Re: Marist Catholic College North Shore
Application No.: SSD-10473

Response to Exhibition of Amended State Significant Development Application

1 CARLOW ST ELEVATION

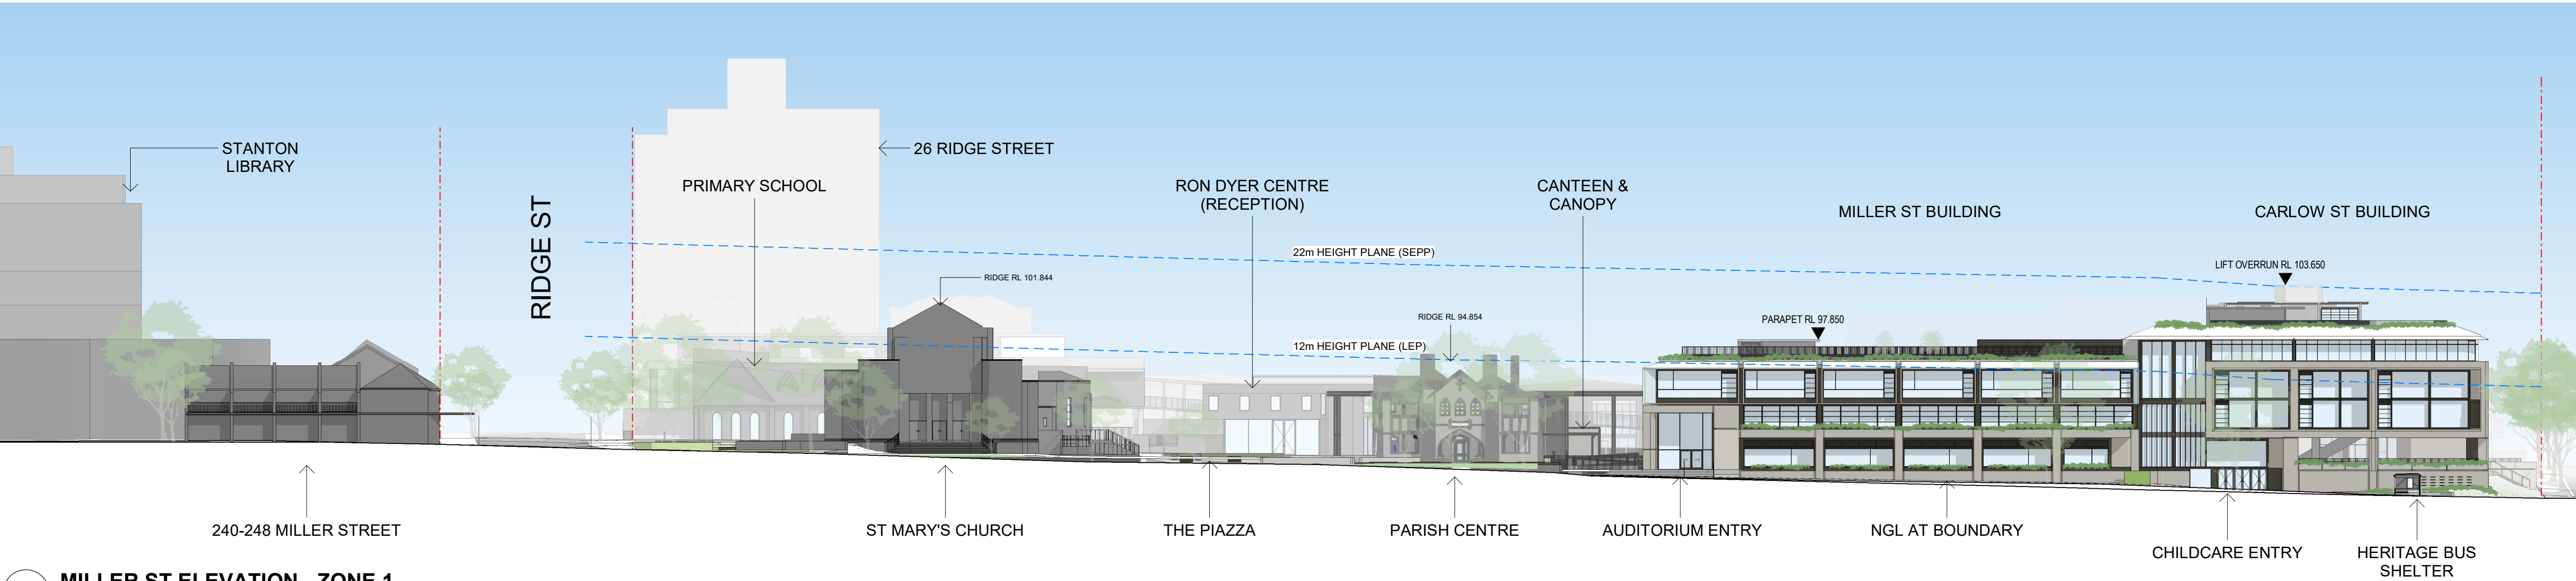
The current plans, indicate the entire Carlow Street Building will now be 4 levels above ground with a rooftop recreation space, resulting in an overall increase in the building mass. As currently proposed, the building's frontage to Carlow Street at its western end will be ~20m (natural ground level). This is significantly higher than any other building in the residential area of Carlow Street and the maximum building height of 12 metres outlined in the North Sydney Local Environment Plan 2013 (Clause 4.3).

It is requested that the building mass be returned to the design outlined in the original concept plan which would provide more alignment with the surrounding residential properties.

4. The lack of acknowledgment in the proposed design to the residential and heritage zone of Carlow Street is highlighted by the reduction in building setback as the building proceeds along Carlow Street. At the corner of Miller and Carlow Streets the setback is 6,300mm due to its substantial height but this is incrementally reduced to 4,400mm as the building progresses to its western end on Carlow Street – where it is opposite and adjacent to residential properties all of which have a significantly smaller footprint.
